Subject: Notice of Exhibition – Luddenham Resource Recovery Facility at 275 Adams Road, (Lot 3 in DP 623799) Luddenham (SSD 10446)

ATTACHMENT A – BIODIVERSITY COMMENTS FOR LUDDENHAM RESOURCE RECOVERY FACILITY SSD 10446

The proposed project layout is shown in Figure 1.2.

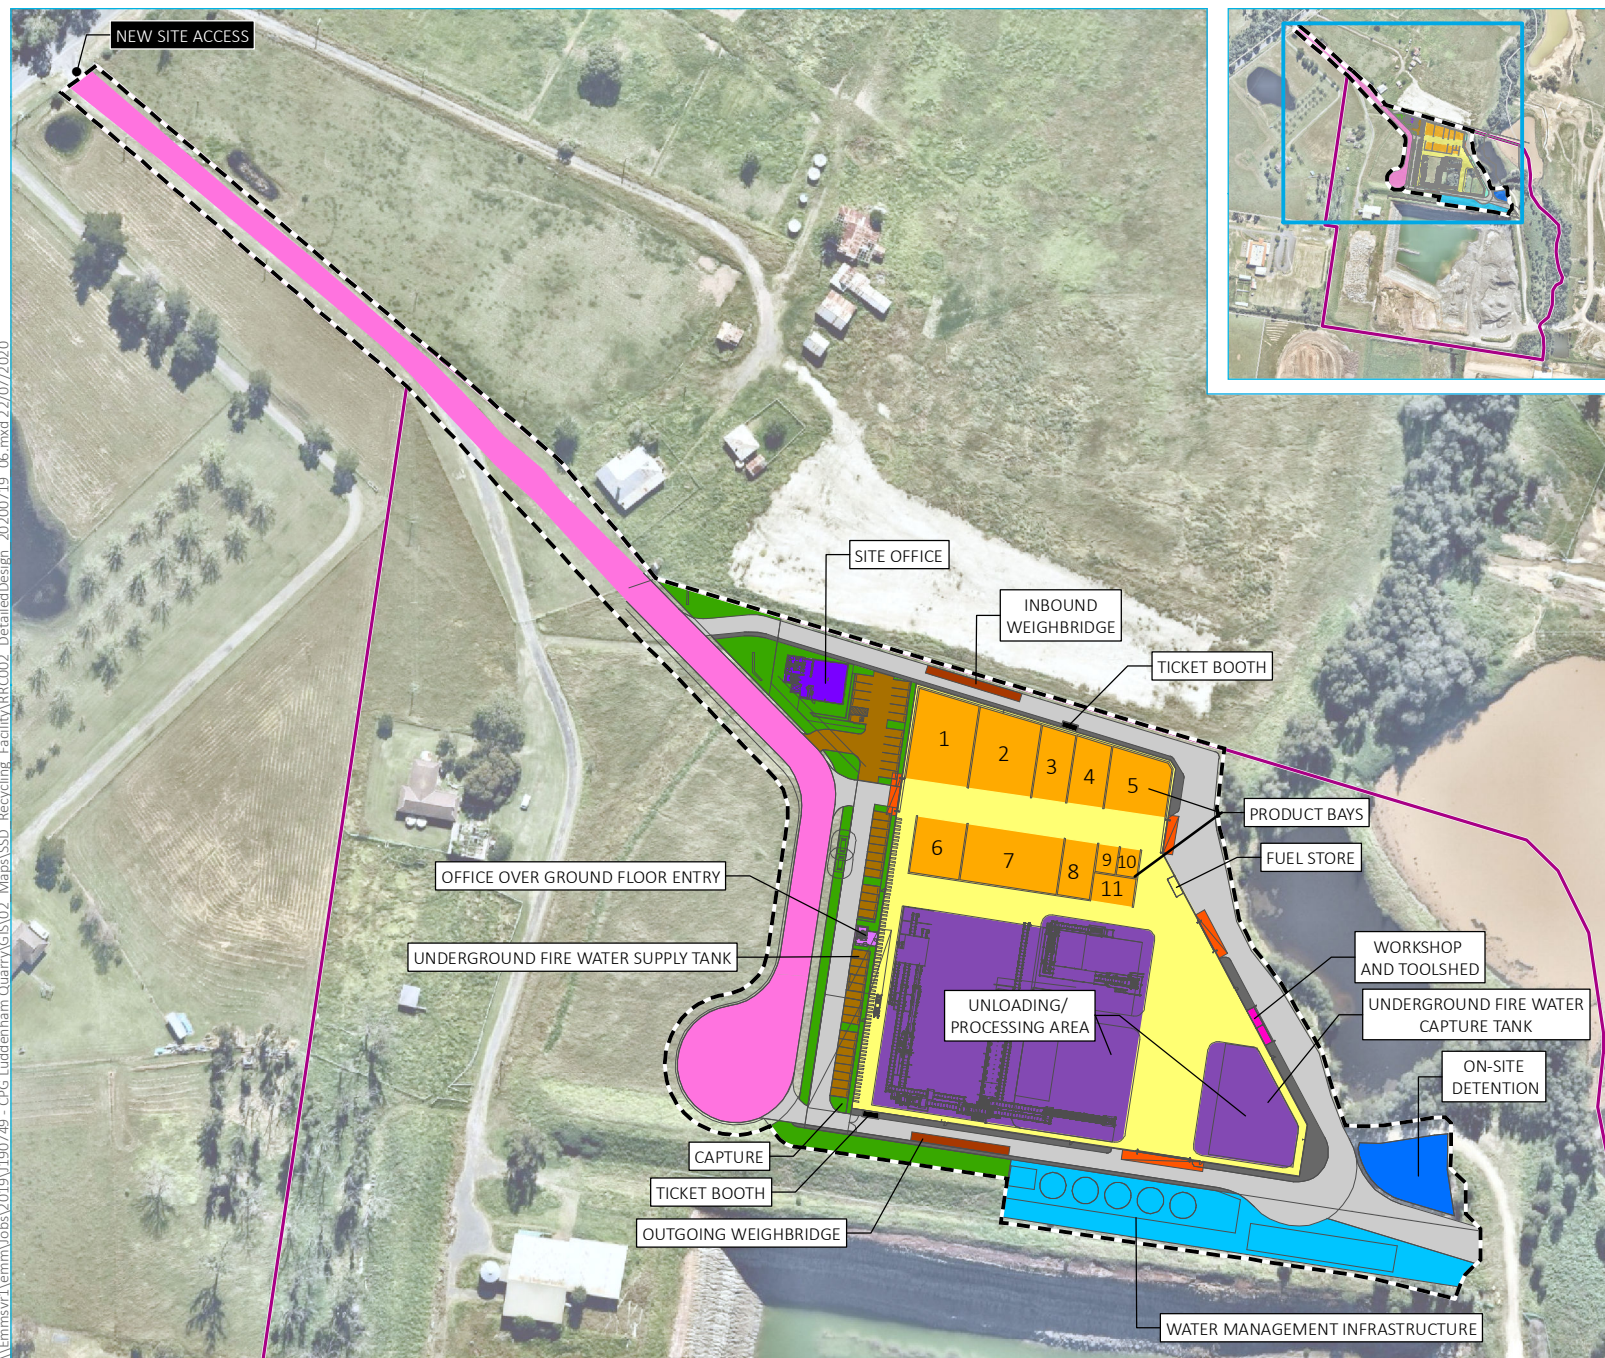
water will be delivered to Oakey Creek but the final drawing of the surface water assessment shows a structure for this (see the drawing titled 'Stormwater Catchment Plan', drawing no. 030, AMDT D). Figure 1.2 of the BDAR shows no such structure and its impacts have not been considered.

The full impacts of the OSD storage needs to be assessed in the BDAR.

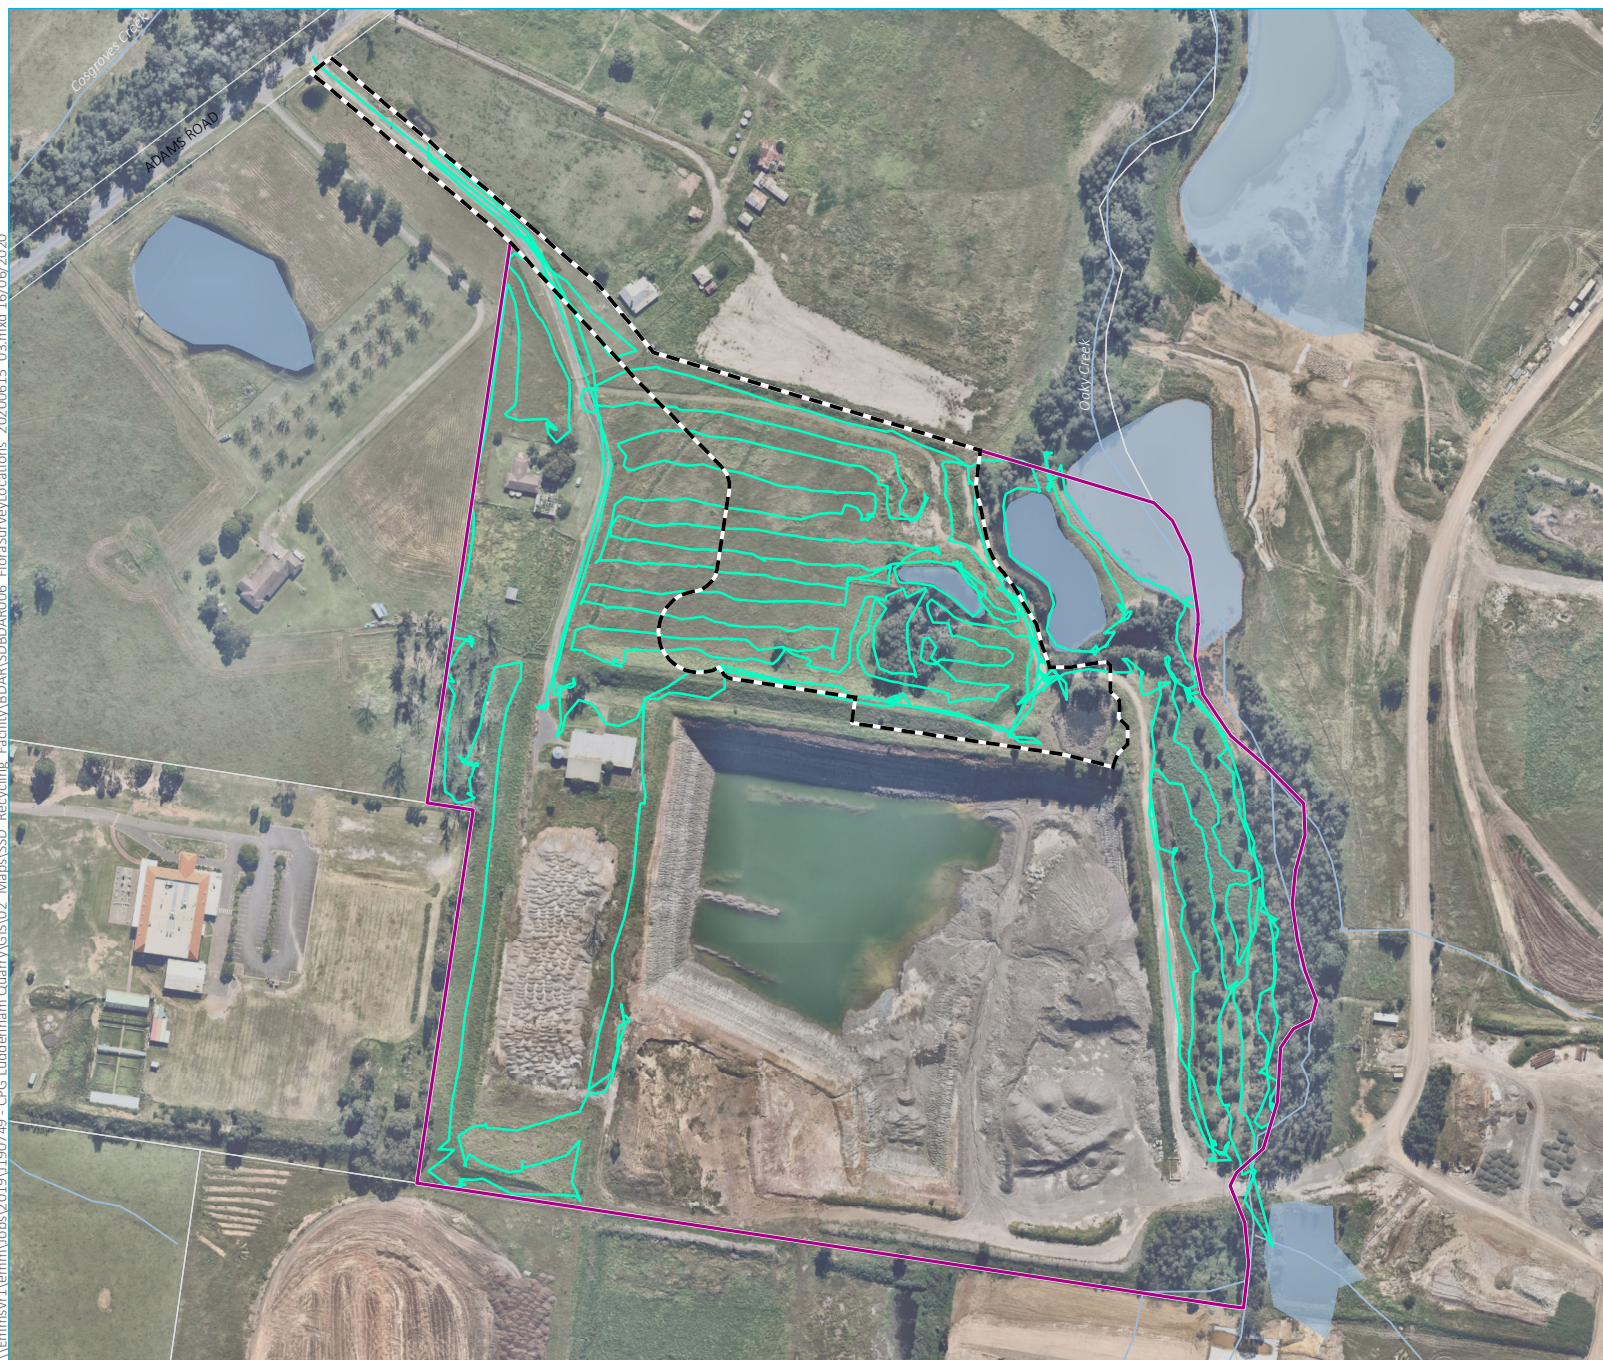
Figure 5.2 shows the survey effort was confined to the vegetation near the dams on the Advanced Resource Recovery Centre (ARRC) site and subject property, and along those parts of Oakey Creek in the vicinity of the subject property. This survey effort is inadequate because potential habitat was not surveyed, because:

- It is estimated that the survey tracks shown in Figure 5.2 occur within 40m of adjacent dams and within 30m of the creek line but more habitat for this species occurs across the subject property.

As such: targeted surveys need to be completed to cover all available habitat on the subject property for this species; diurnal surveys need to be carried out; and information needs to be given on the location of the reference population and when and how it was observed, and what was observed.

The BDAR contains inconsistent information relating to the targeted survey for Cumberland Plain Land Snail (CPLS). Table 5.13 shows the search was confined to the Cumberland Plain Woodland on the subject property (PCT 849) but Figure 5.2 shows transects were done across a much larger area. These transects however, appear to be the same as those shown in Figure 5.1 (that is, they are one and the same as the targeted flora searches) and Table 5.4 states, in relation to CPLS, “Species associated with PCT 849 which is located outside of the impact area.”

Although the BDAR does not mention dewatering dams, it is conceivable that this will be needed for some of the ponds shown in Figure 5.2.
